Ref TR 010018/10030804

Representation No 412

Deadline 2 Representations

A14 Cambridge to Huntingdon Improvement Scheme

Drawing title: **RIGHTS OF WAY & ACCESS PLANS REGULATIONS 5(2)(k) & 5(2)(c) SHEET 10 OF 28**

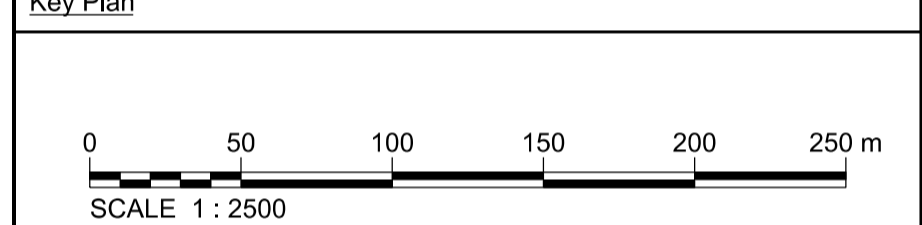
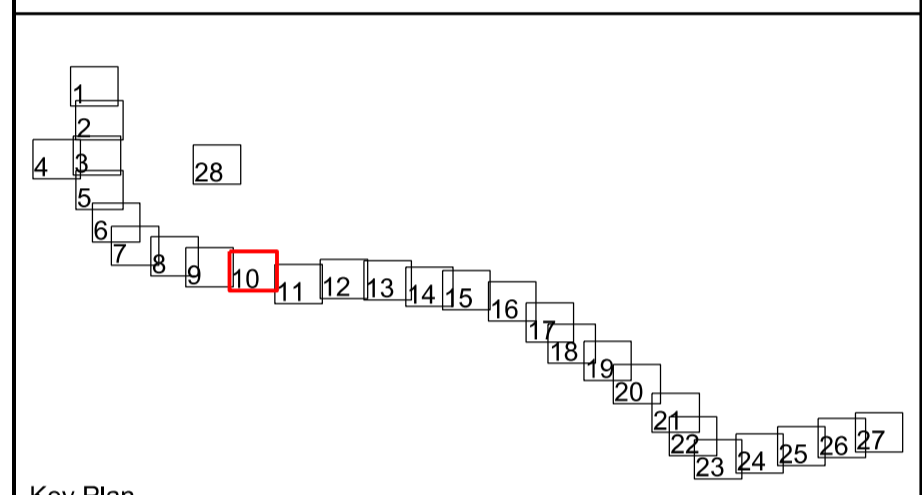
2. Our clients note the proposals on sheet 10 of the Rights of Way and Access Plans which impact on the existing farm access arrangements. The access to the farm is stopped up at point a, but the replacement alternative means of accesses numbered 1 is an existing track and there appears to be inadequate provisions to ensure adequate legal access between the metalled highway and the side road boundary fence.

4. Our clients note that sheet 10 of the Rights of Way and Access Plans identify boundaries for the trunk road and side road which exclude the areas referred to at 3 above. Our clients are concerned as to who will be responsible for the maintenance and care of these areas and are concerned regarding possible shading of crops.
